**Our Case Number:** ABP-314724-22

**Re:** Railway (Metrolink - Estuary to Charlemont via Dublin Airport) Order [2022]  
Metrolink. Estuary through Swords, Dublin Airport, Ballymun, Glasnevin and City Centre to  
Charlemont, Co. Dublin

Railway  
(Metrolink-Estuary to Charlemont  
via Dublin Airport)  
Order 2022  
2<sup>nd</sup> Public Consultation

Observations on Documents  
Submitted During the Oral Hearing

Drawing Title	METROLINK - GENERAL ARRANGEMENT SEATOWN (SHEET 1 OF 3)		Drawing Status	S1
Drawing N°	ML1-JAI-ARD-ROUT_XX-DR-Y-03012	Plan Drawing N°	ML-RO 301 H-J	
Scales Original Size A1	AS SHOWN	Sheet	1	of 1

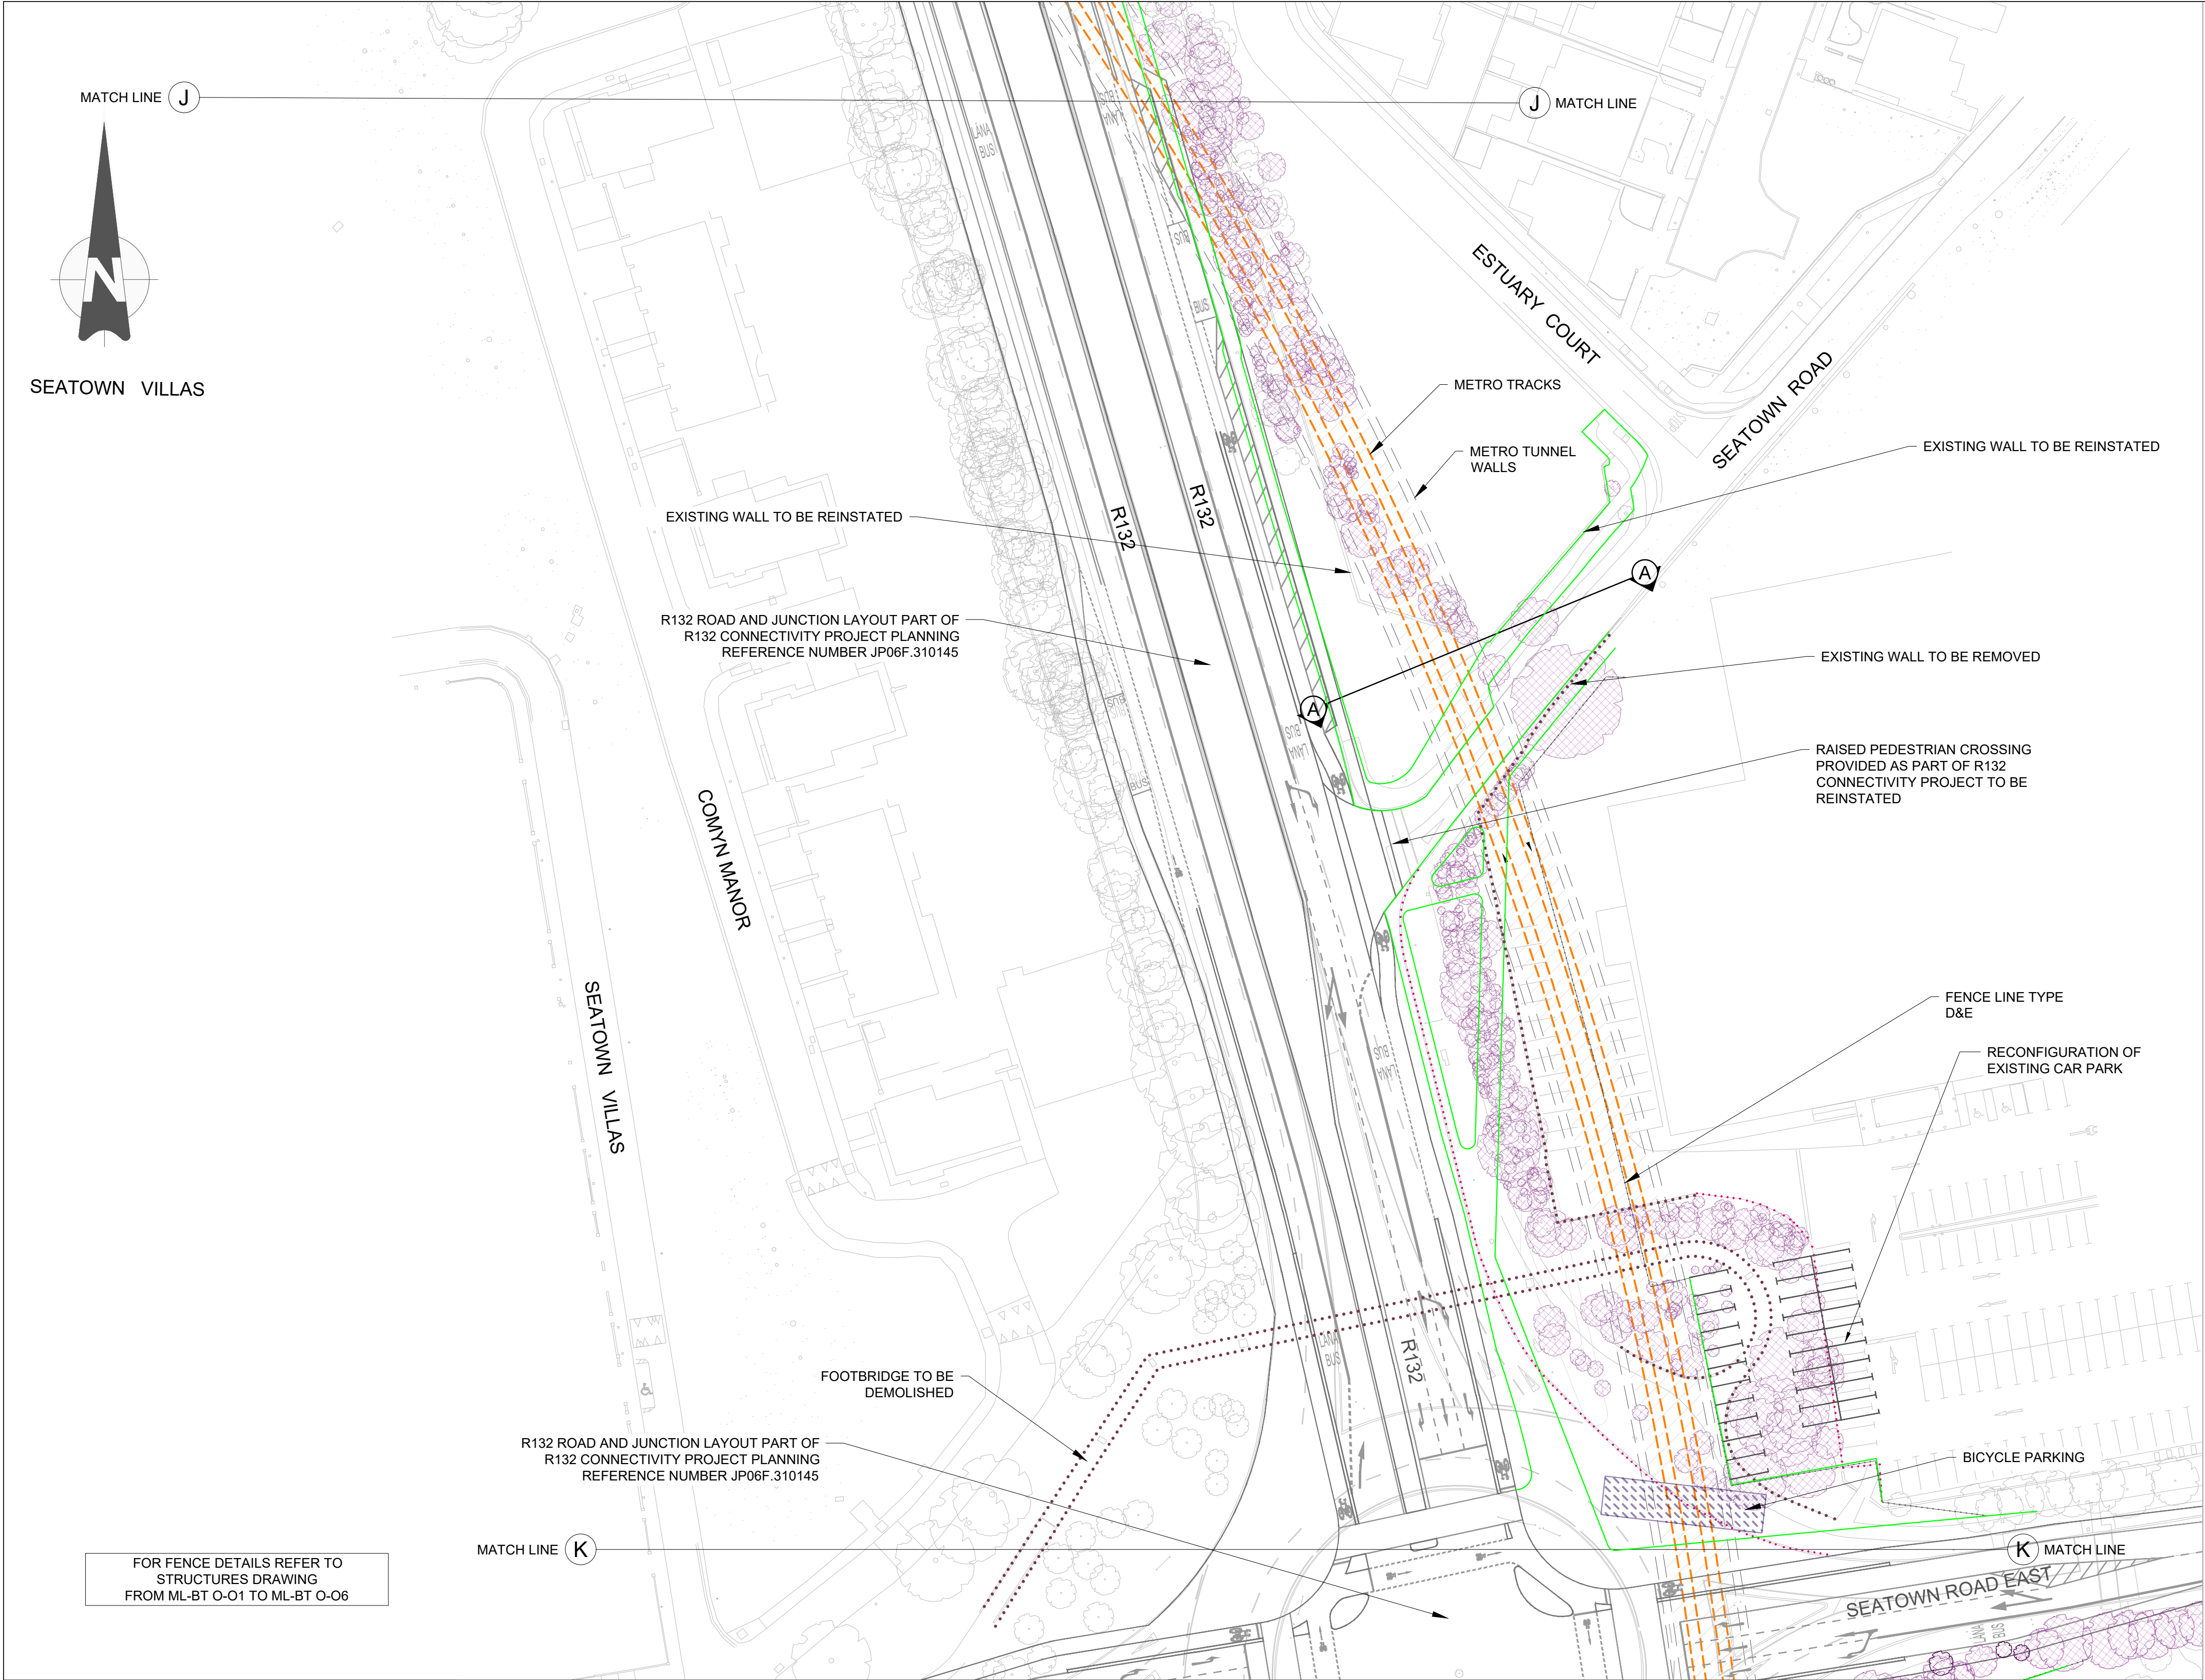
The extract below from Drawing ML-RO 301 H-J S1 shows that the existing trees and vegetation along the R132 on our north green are to be retained. We would very much welcome this and we request the TII now commit to not occupying our north green as a construction compound.

Outline Construction Programme

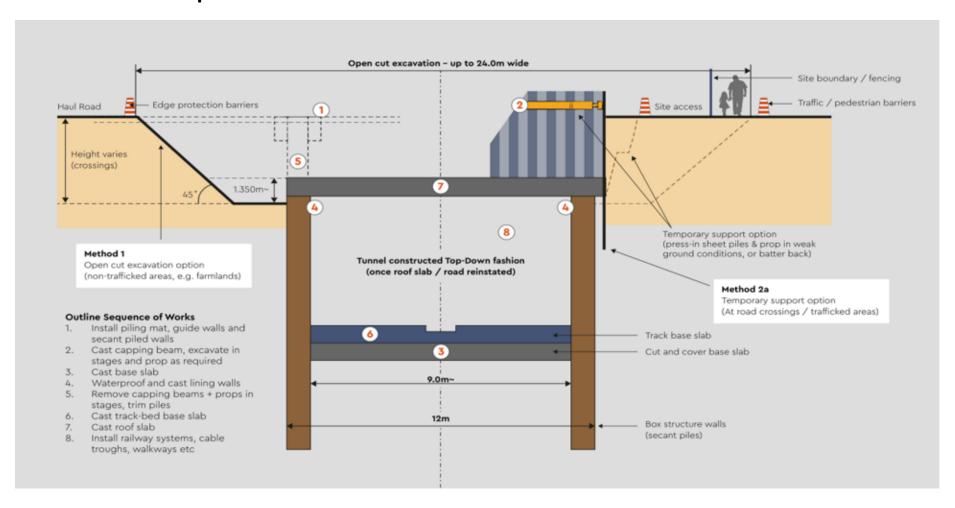
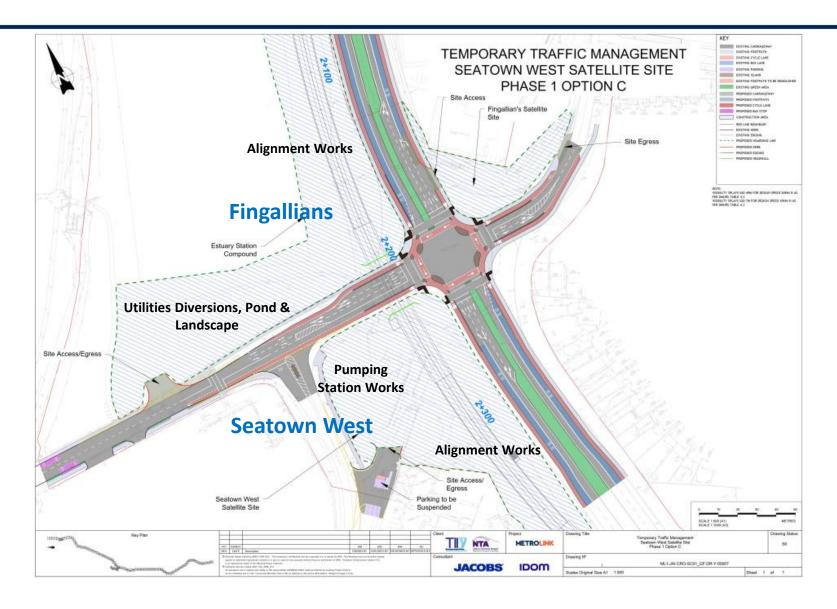
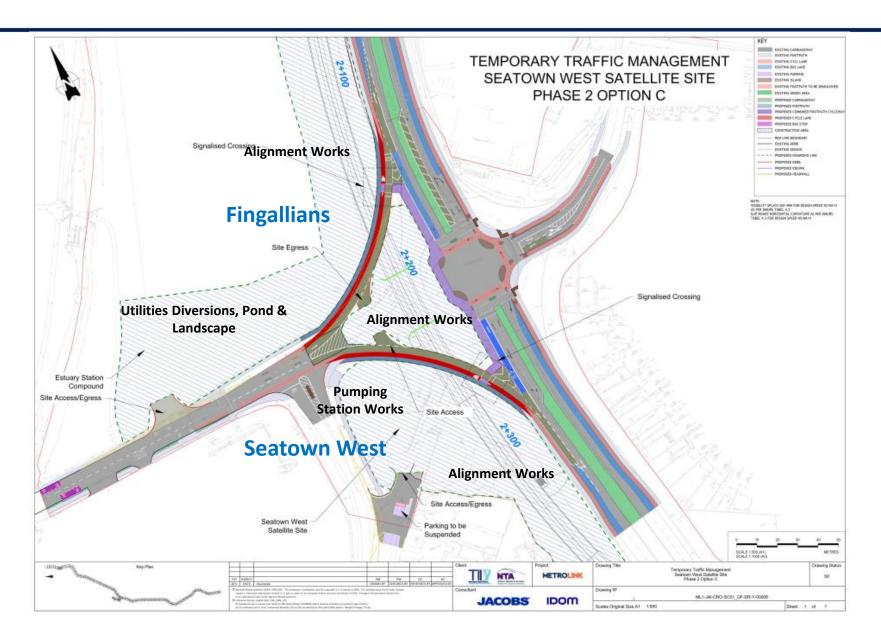
A timeframe for the proposed TII compounds in the Estuary Court area was issued on the 21<sup>st</sup> February 2024, a few days after the Oral Hearing started. At the second module of the Oral Hearing, we raised the point regarding the extraordinary length of time that the TII propose to occupy the 2 greens in Estuary Court - 40 months (4 enabling + 36 construction – see Fig 1 below). There is 105 metres of cut and cover tunnelling to be constructed in Estuary Court which is a very small section of the overall project (18.8km).

The TII have set out that they will complete 18,800 meters of the Metrolink in 8 to 9 years however, to complete just 105 metres in Estuary Court they will require full occupation of our greens for approx. three and a half years? Based on these high-level figures, it is clear that it will not take this length of time to construct 105 metres of Metrolink.

**We request that the TII provide a construction programme for the section of cut and cover tunnel in Estuary Court (105 metres).**

**We request that the TII significantly reduce the occupation time of the South Green to reflect the actual construction time required to this section.** The landscaping should then be restored as soon as the cover is complete on the tunnel.

**We request that the TII withdraw their proposal to occupy the North Green.**
